From: Adam King [REDACTED]
Sent: 26 November 2019 17:08
To: Anita Gardner <Anita.Gardner@arun.gov.uk>
Subject: RE: Planning Application R/230/19/PL - Springfield House, Springfield Close, Rustington, BN16 2SZ - Objection

Subject: Planning Application R/230/19/PL - Springfield House, Springfield Close, Rustington, BN16 2SZ - Objection

Further to the site notice seen for Planning Application R/230/19/P, we write to object to the proposed relocation and significant enlargement of the garage onto the eastern boundary and to the accommodation on the first floor of the garage. We own the neighbouring property to the east of the Application site and will be directly affected by the proposal.

Job Title	Springfield House		
Client	Castle Property Developments		
Drawing Name	Garage - Plan & Elevations		
Drawing Status	Planning		
Drawn by	DF	Date	Sept 19
Checked by		Date	
Drawing Scale	1:50 & 1:100 at A1		
Drawing No	Status	Revision	
181303/	09

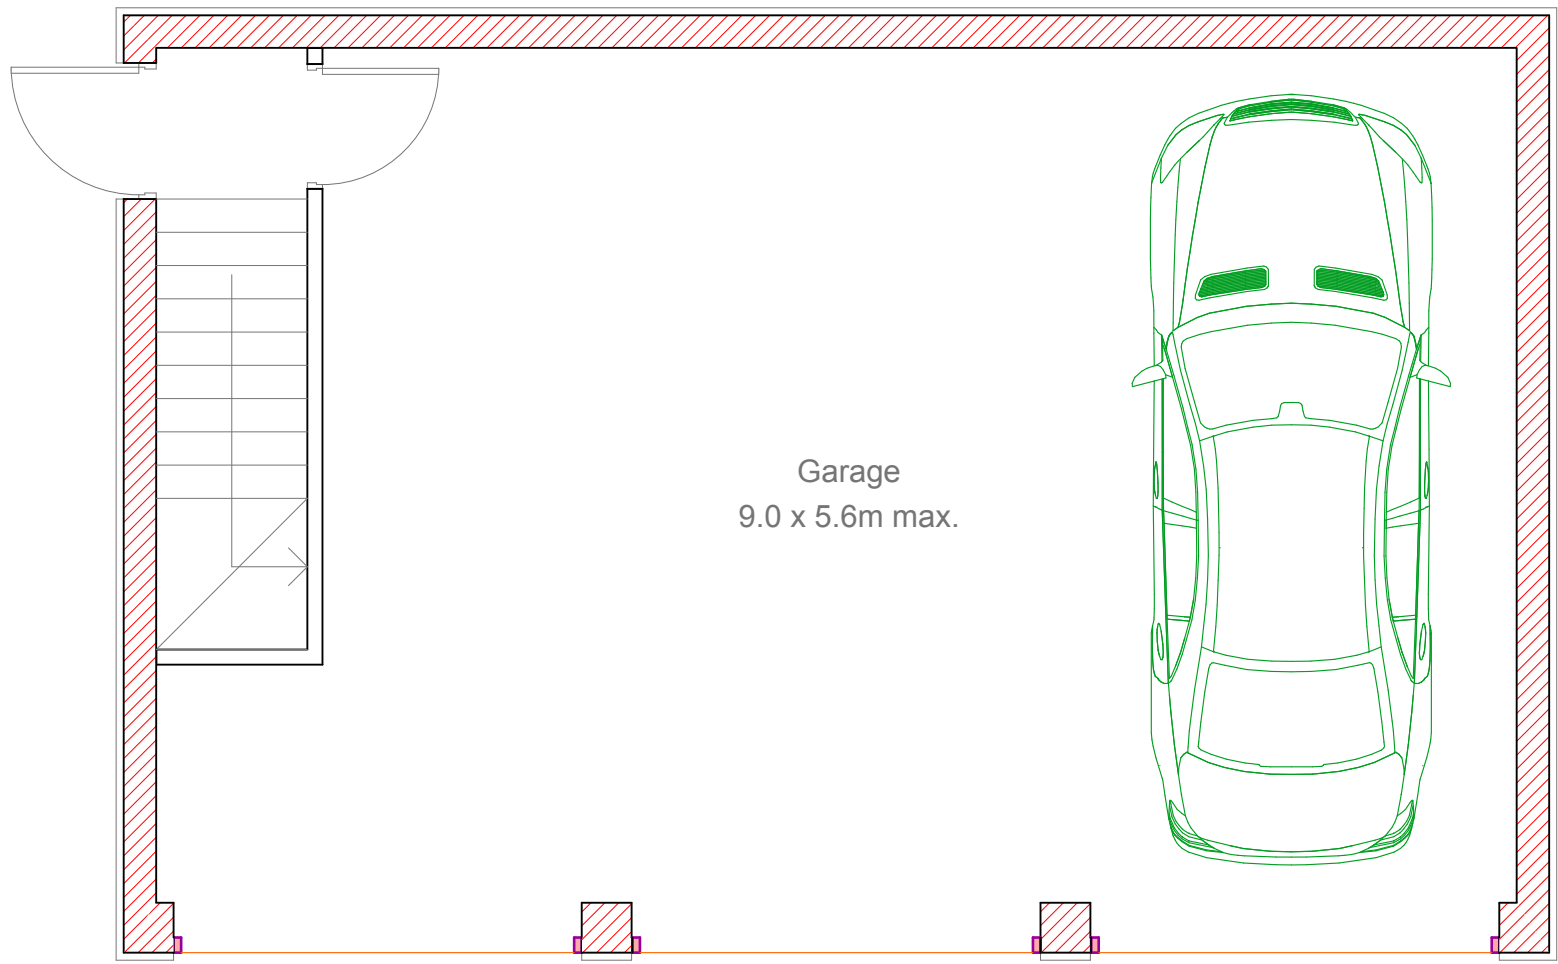
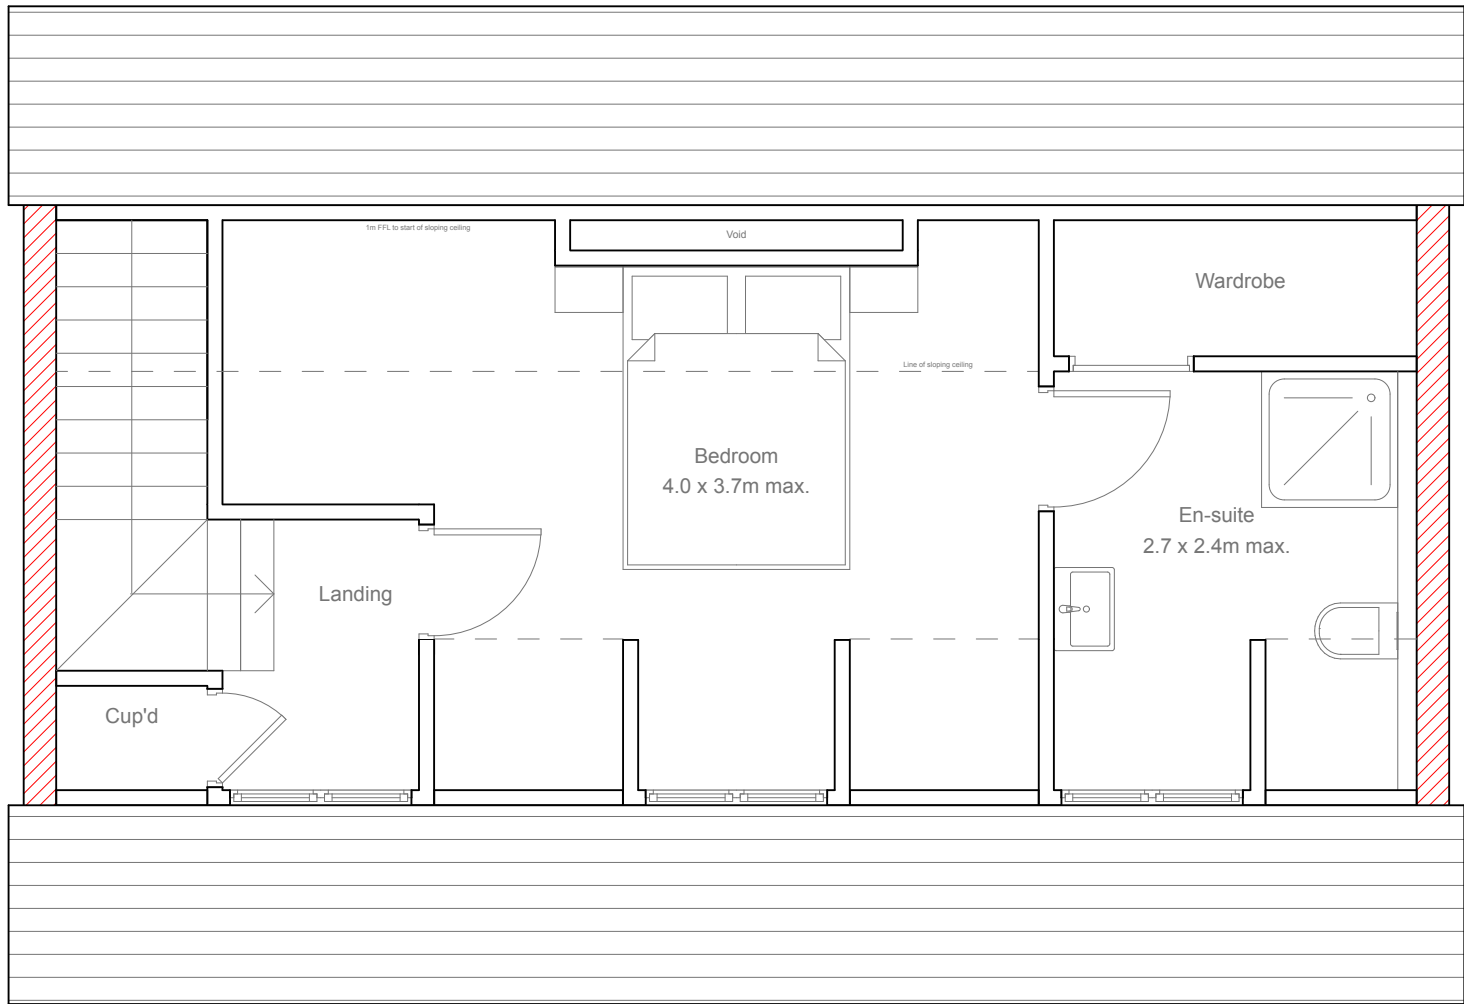
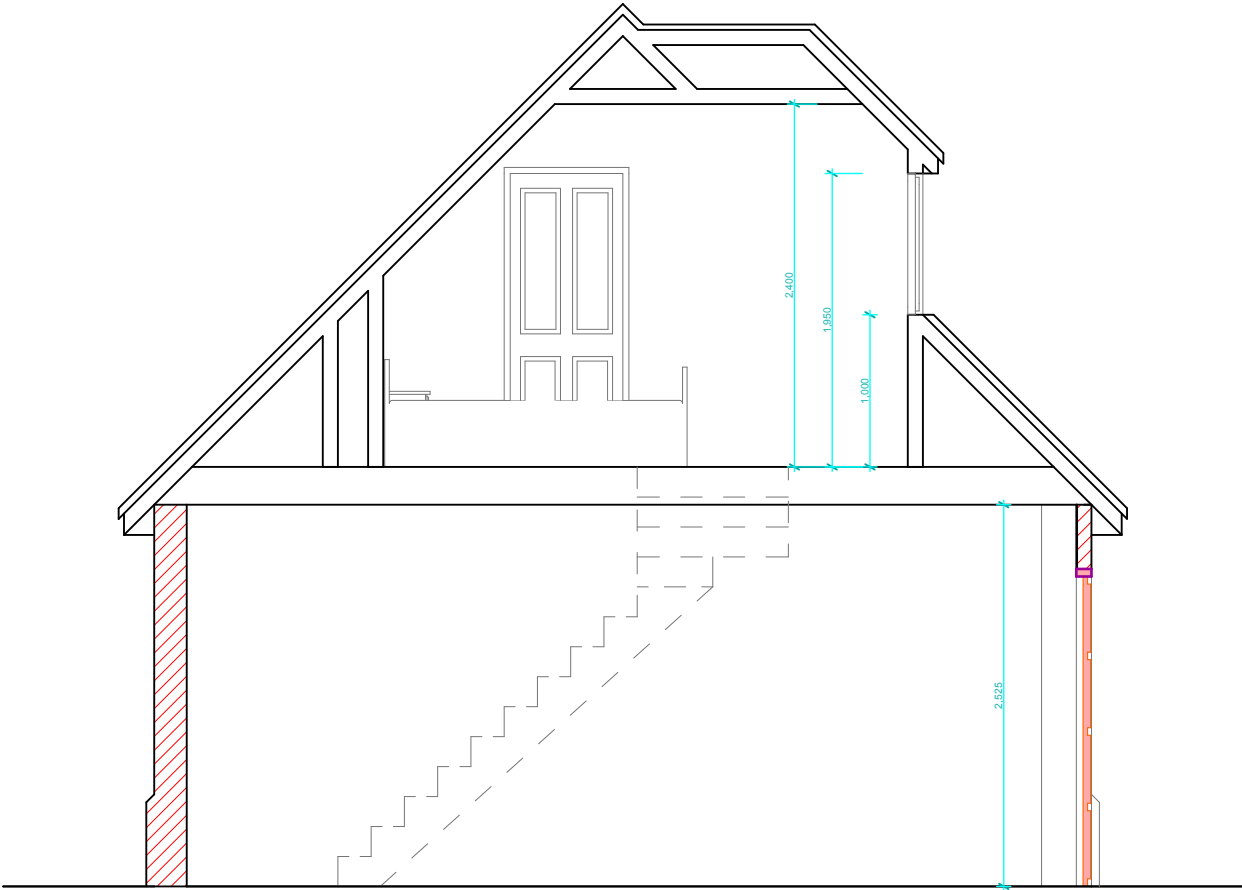
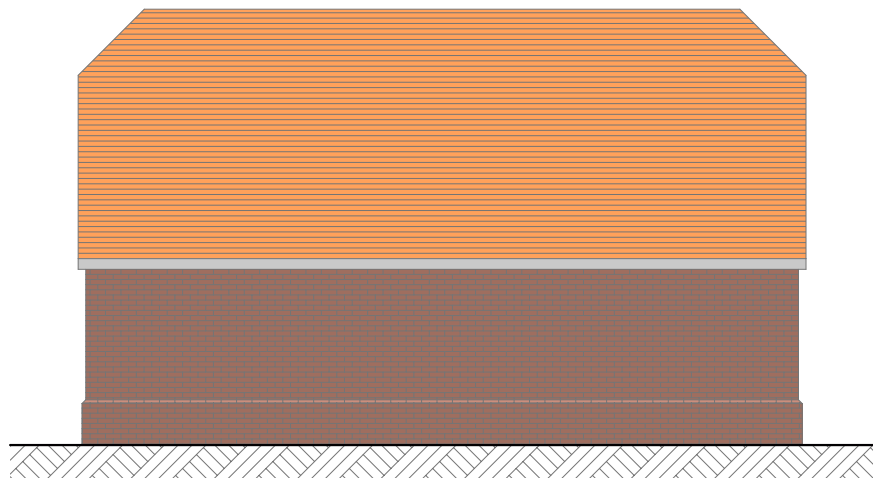
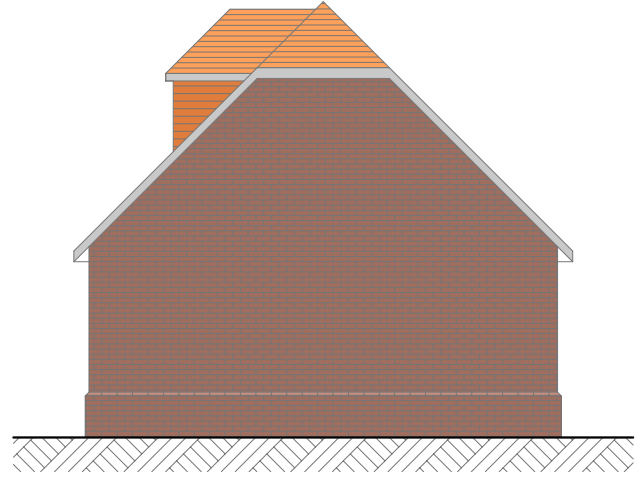
The existing Planning Permission locates the approved double garage well away from our western boundary, meaning that an appropriate distance is maintained between the built forms across the two dwellings and most importantly provides an area for landscaping to provide adequate visual separation between the houses. The proposed location of the garage block in this Application renders this impossible, with only a notional 1m gap to the fence boundary. The building will be highly visible from our garden given its insensitive design; a large gable will be present only 1m from the boundary as a direct result of the intent to provide accommodation at first floor; this is completely contrary to the existing consent which had a garage building with a low pitched roof to be subordinate to the main house.

The proposed building has now increased dramatically to a triple garage and first floor accommodation from the approved much smaller double garage. Positioning the new garage block as proposed will create an uncomfortable relationship with our garden and provide anyone using the bedroom above the garages the ability to look directly in a south easterly direction into our garden from any one of the 3 dormer windows proposed. Applying for additional accommodation is unnecessary in itself given the size of the approved house, and the plans suggest that this could become a self-contained annexe separate from the house. This is completely at odds with the current Planning Permission.

We believe that the proposed building has both an overbearing and overlooking impact on our property, decreasing the ability to quietly enjoy our garden. The large gable will loom ominously over our eastern boundary and be a very hard edge to the current unencumbered views of the boundary trees. We believe that the proposed garage has been 'shoehorned in' to try to (just about) avoid the trees on the northern boundary, namely Trees 16 and 17. The previous siting of the garage fully respected the RPAs of T16 and T17, but the proposed large block appears to encroach into

the RPAs to a more significant degree than the Arboricultural Report would appear to suggest. No details of foundation design have been provided, however the likely strip foundations will have an effect on these trees.

To conclude, we object to the siting, scale, massing and design of the proposed garage block and additional annexe accommodation for reasons of inappropriateness, significant overlooking, overbearing impact on our garden, likely impact on Trees 16 and 17, inappropriate landscaping provision to the site boundary and most importantly the loss of privacy to our property caused by the proposed new accommodation. We would respectfully ask that the Planning Application is refused.
